ATTACHED TO ADMINISTRATIVE APPROVAL
 DATED: October 6, 1999
 BY: MARTIN R. CRAMTON, JR.

TECHNICAL DATA SHEET
 PETITION NO. 98-97 FOR PUBLIC HEARING

DATE: October 6, 1999

SUBJECT: Administrative Approval for Petition No. 98-97 by Childress Klein Properties, Inc. Tax parcels 123-041-14, 123-041-15-21 and 123-041-23.

TECHNICAL DATA SHEET
 PETITION NO. 98-97 FOR PUBLIC HEARING

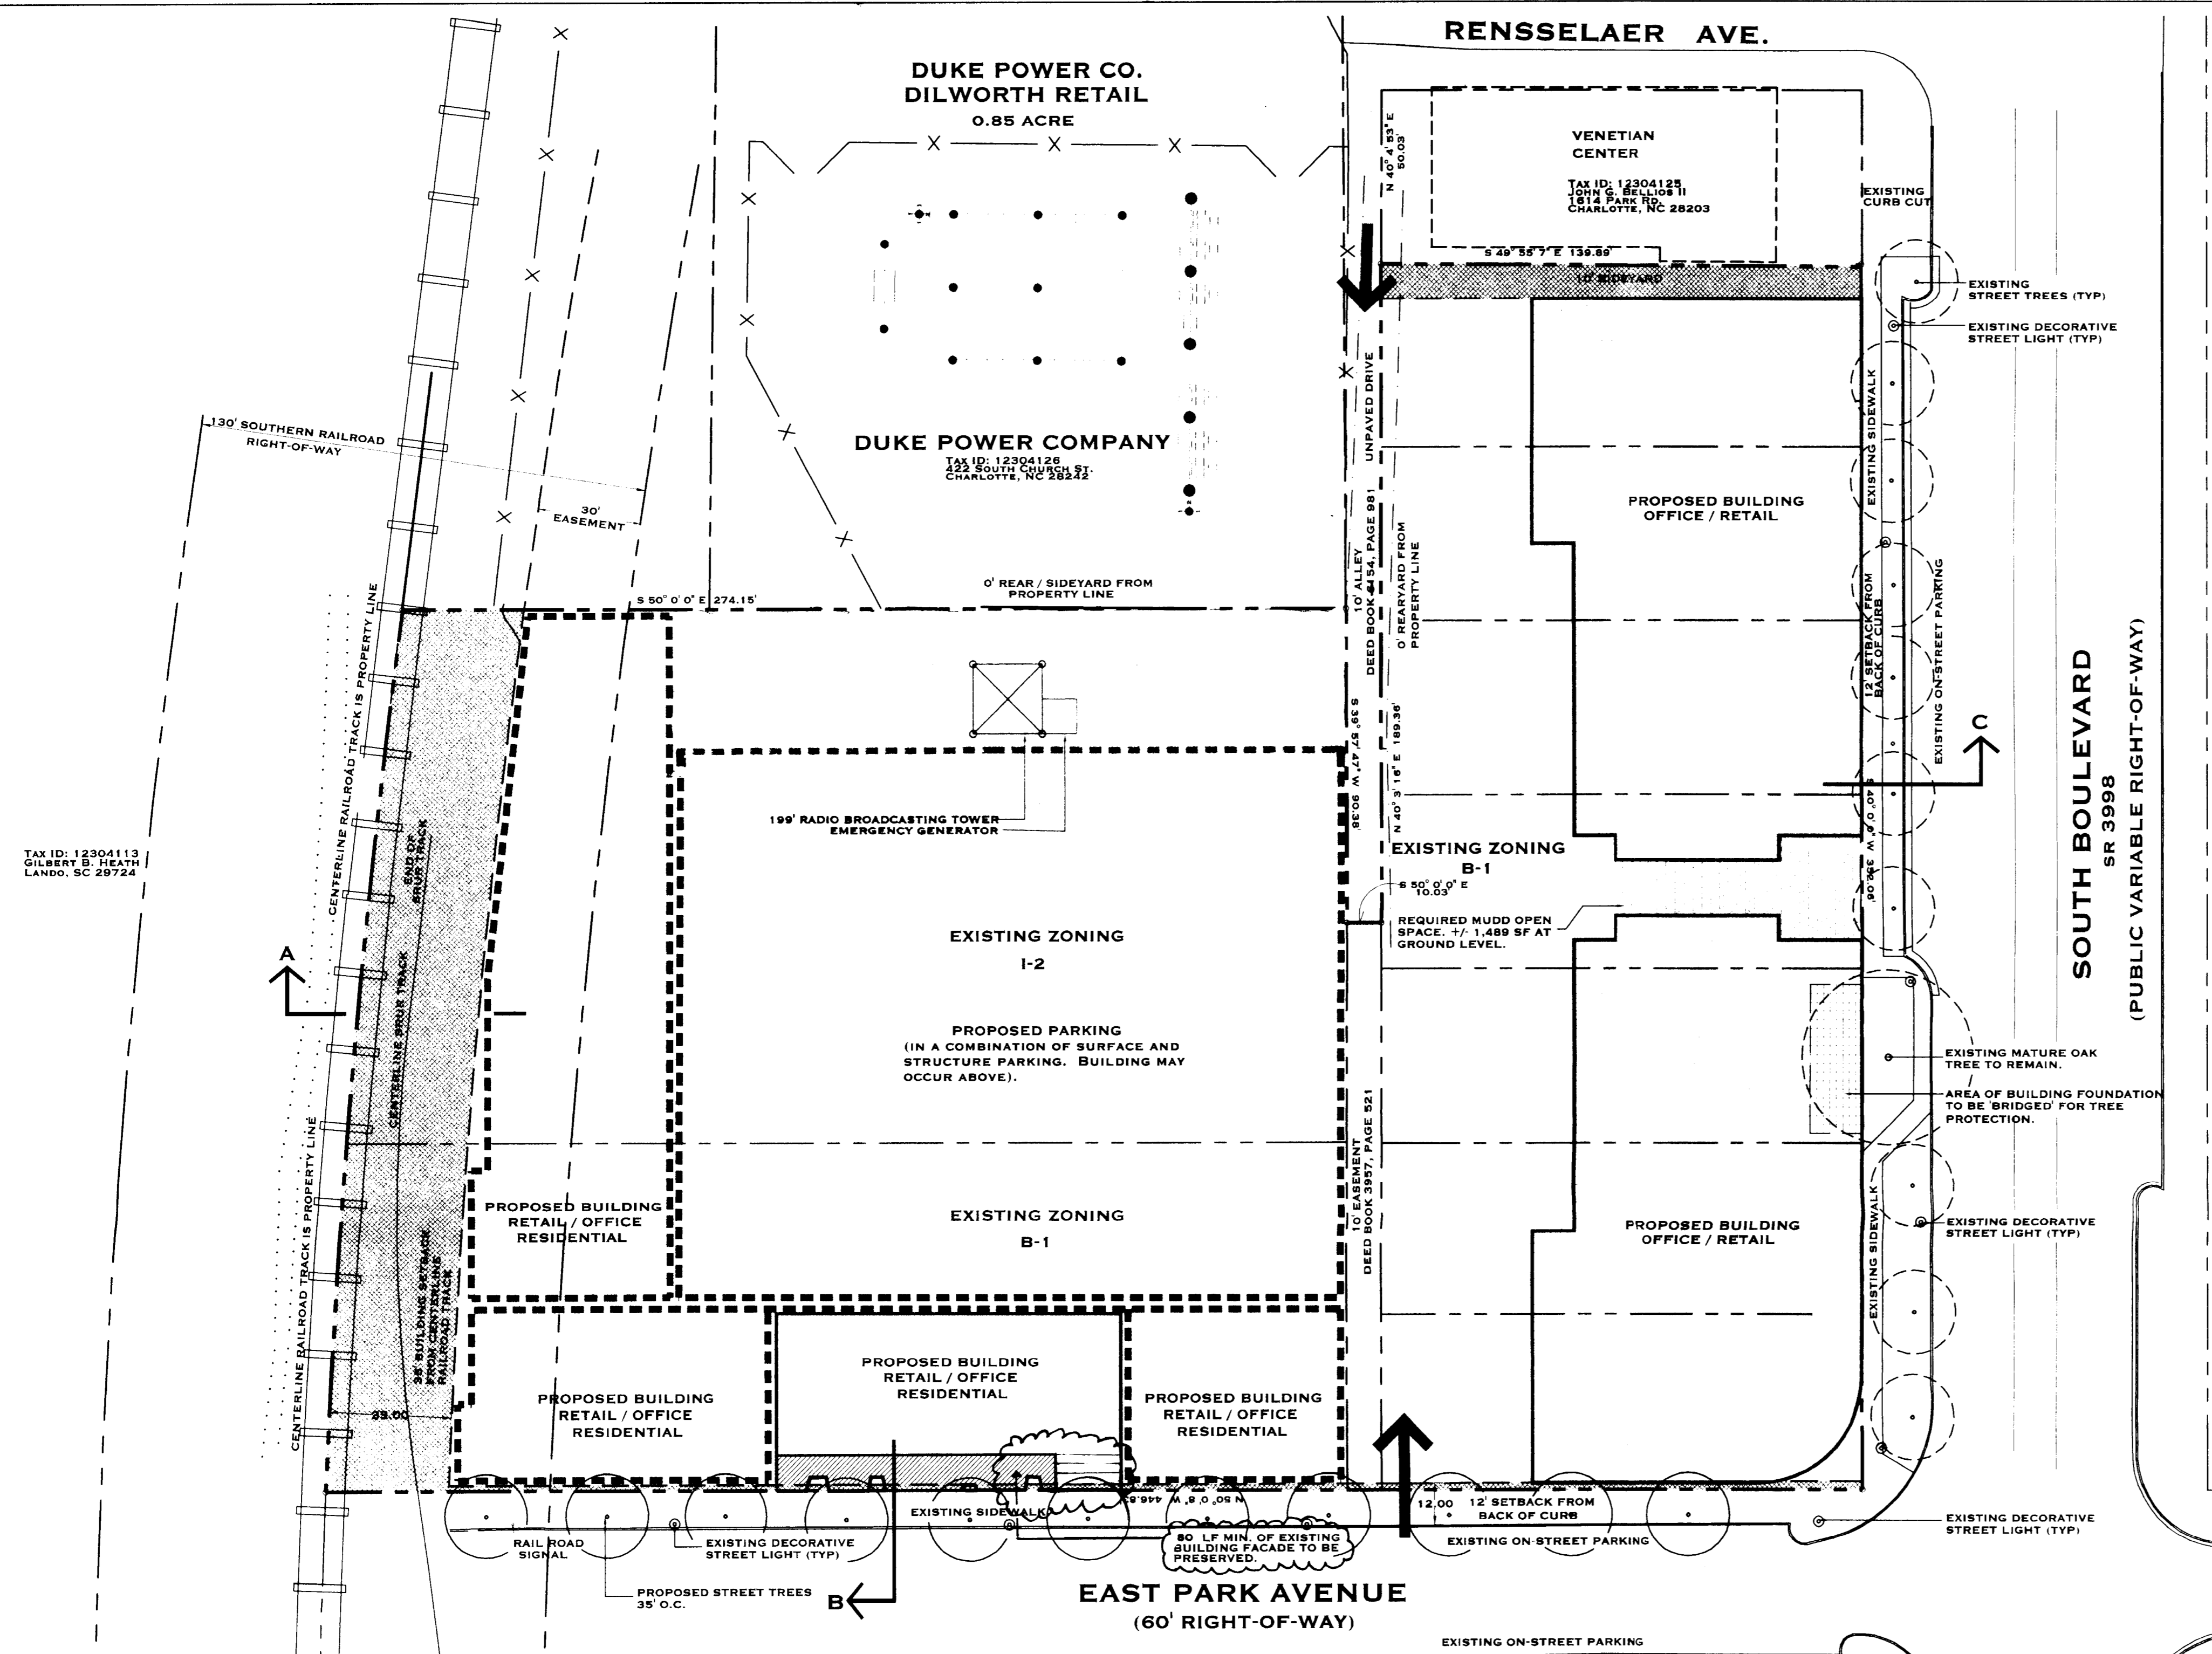
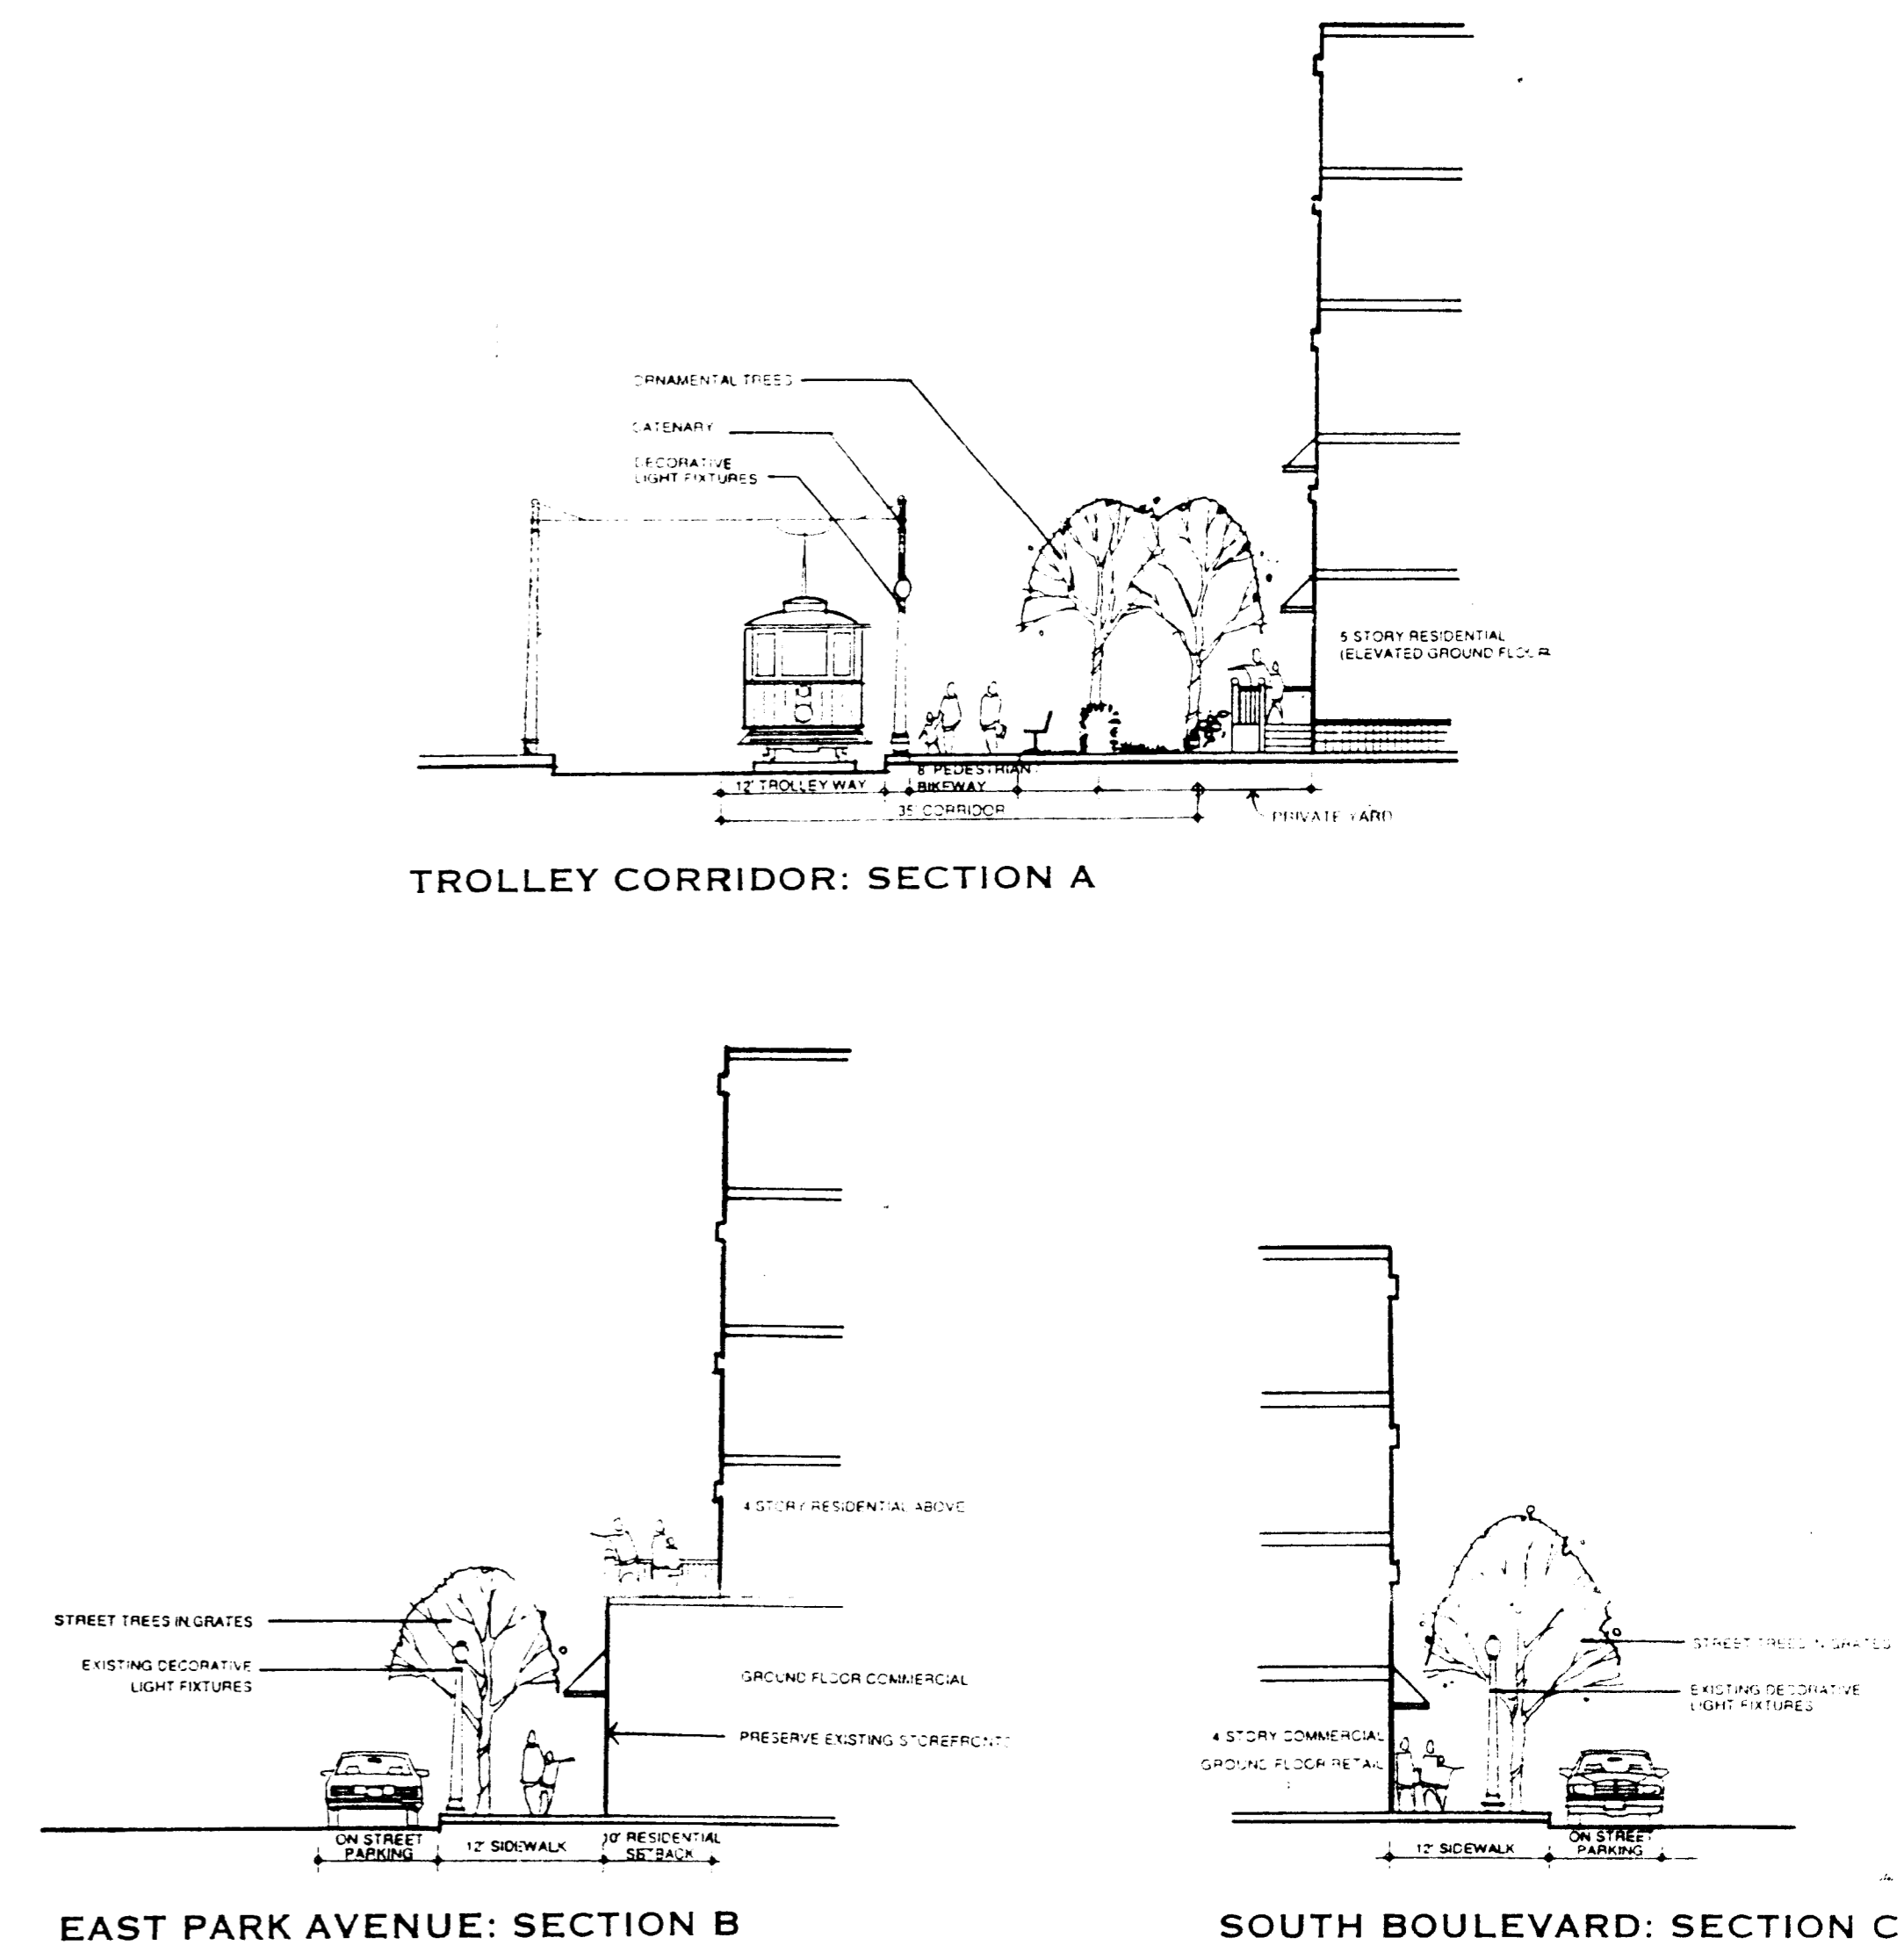
Attached is a copy of the revised plan for the above rezoning petition. The plan has been revised to reduce the amount of building facade that will be preserved along East Park Avenue from 100 feet, to 80 feet. Since this change is minor and does not alter the intent of the development, I am administratively approving this revised plan. Please use this revised plan when evaluating request for building permits and certificates of occupancy.

Existing Structures
 The existing structures on the site shall be razed, except for the preservation of 80 LF minimum of building facade along East Park Avenue as shown on the plan.
